Our Ref: BE/28/22/NMA

**Section 96A of the Town & Country Planning Act 1990 (as amended)
Town and Country Planning (Development Management Procedure) (England) Order 2015
(as amended) - Article 10**

Non material amendment following BE/135/18/PL for alterations to approved external appearance of Units 6/7 and minor roof amendments.

Units 6/7 Land at Saltbox West of Shripney Road Bognor Regis PO22 9NW

Drg No **KP-281-Units 6/7-NMA-02**

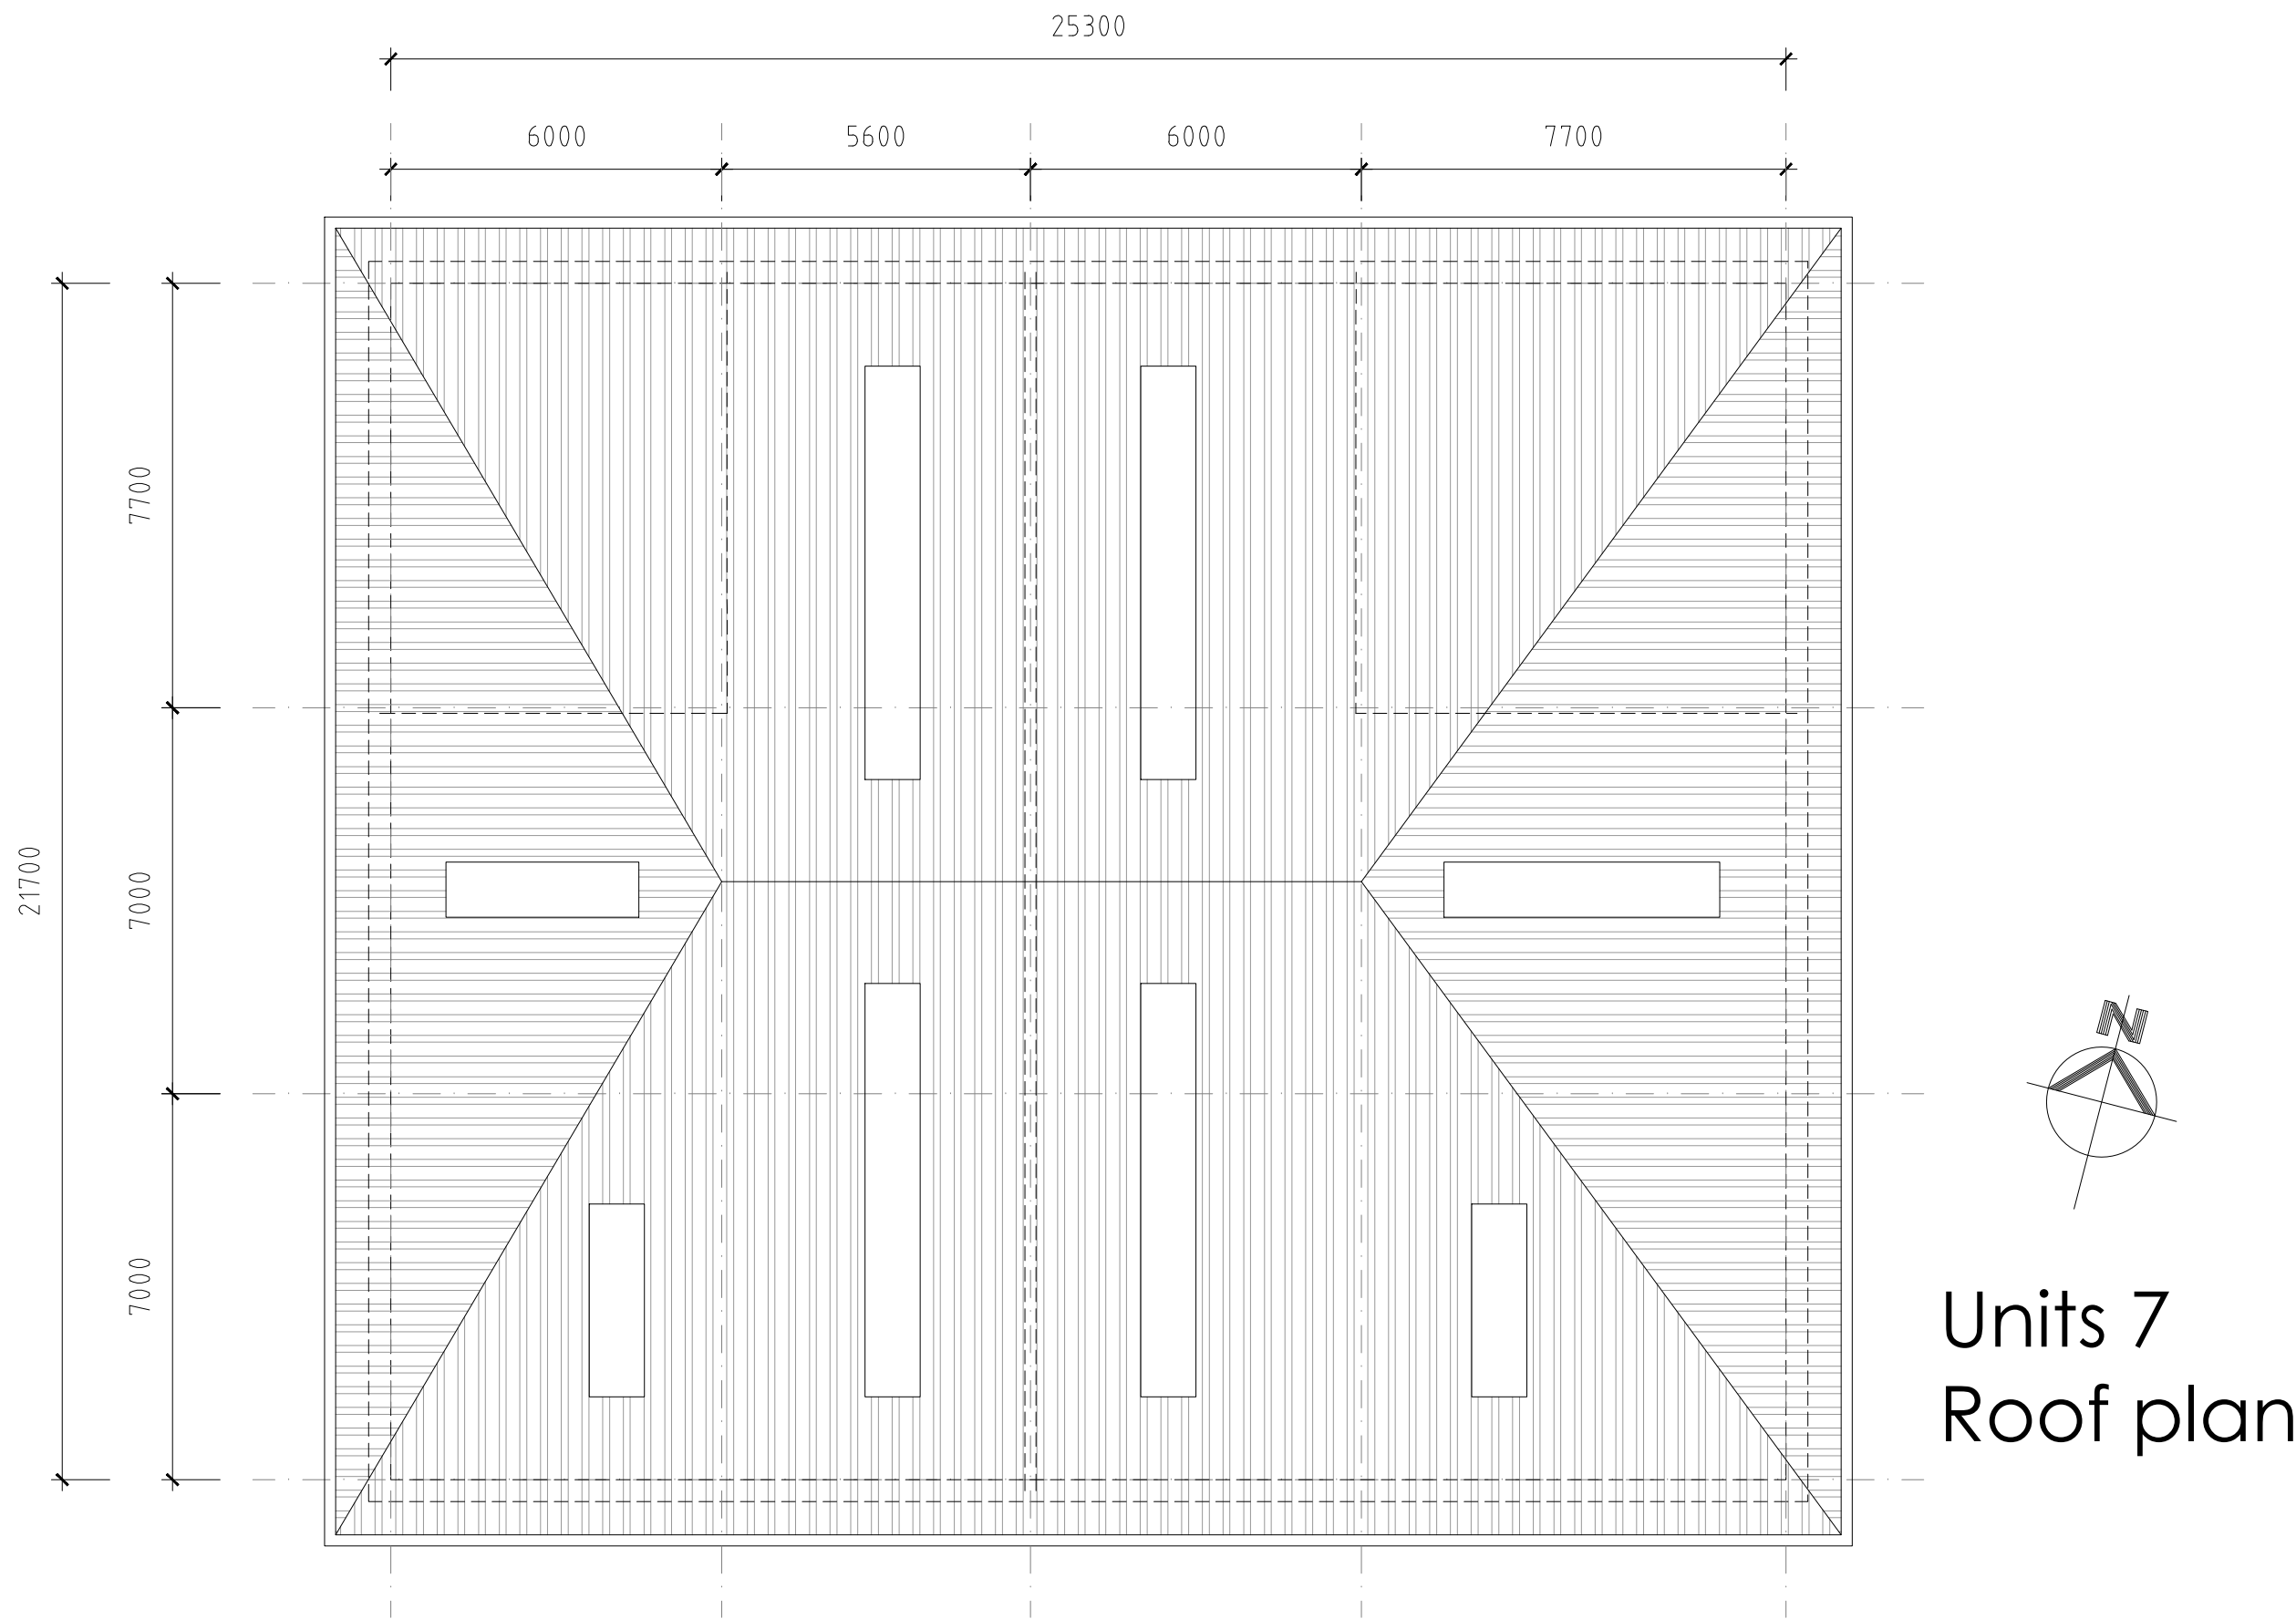
This Non-material amendment application seeks to change the roof to incorporate hip features at the west and east ends of the Unit 6 and 7. In addition to this, there are also proposed changes to the external materials. The units will continue to accommodate the intended 42sqm of Solar PV on the roof as approved under NMA application (BE/125/21/NMA dated 10th August 2021). There are no changes to the site layout scale or dimensions of the approved buildings.

The reason that this proposal has been accepted as a Non-Material Amendment is because it is amending the roof form, and materials of Unit 6-7. The proposal can therefore be considered under Section 96A of the Town and Country Planning Act 1990. As proposed change to a hipped roof and choice of materials would not change the description or conflict with any conditions imposed on the original planning application. The external materials now included:

- Profiled built-up roof cladding in HPS200 Goosewing Grey BS A10A05
- Circular RWPs in Grey Aluminium RAL 9006 or Sargasso Blue RAL 5003 to match adjoining

cladding.

- Gutter fascia in Grey Aluminium RAL 9007
- Horizontally laid profiled built-up wall cladding (half-round or trapezoidal) and related flashings in Metallic Silver colour RAL 9006
- Horizontally laid Microrib composite wall cladding in Sargasso Blue RAL 5003
- Horizontally laid Microrib composite wall cladding in Grey Aluminium RAL 9007
- Coloured insulate loading doors in Grey Aluminium RAL 9007
- Powder coated windows and curtain walling in RAL 9007
- Fire escape doors in RAL 9006 to match cladding
- Glazed spandrel panels
- Turn opening windows
- Unit name panatrim boards

Ian King Associates KP-281-Units 6/7-NMA-01 and KP281-Units 6/7-NMA-02 now form part of the approved planning drawings for BE/135/18/PL at Saltbox in place of:

1744-TU-P04B (Proposed Roof Plan) and 1744-TU-P05C (Proposed Elevations)
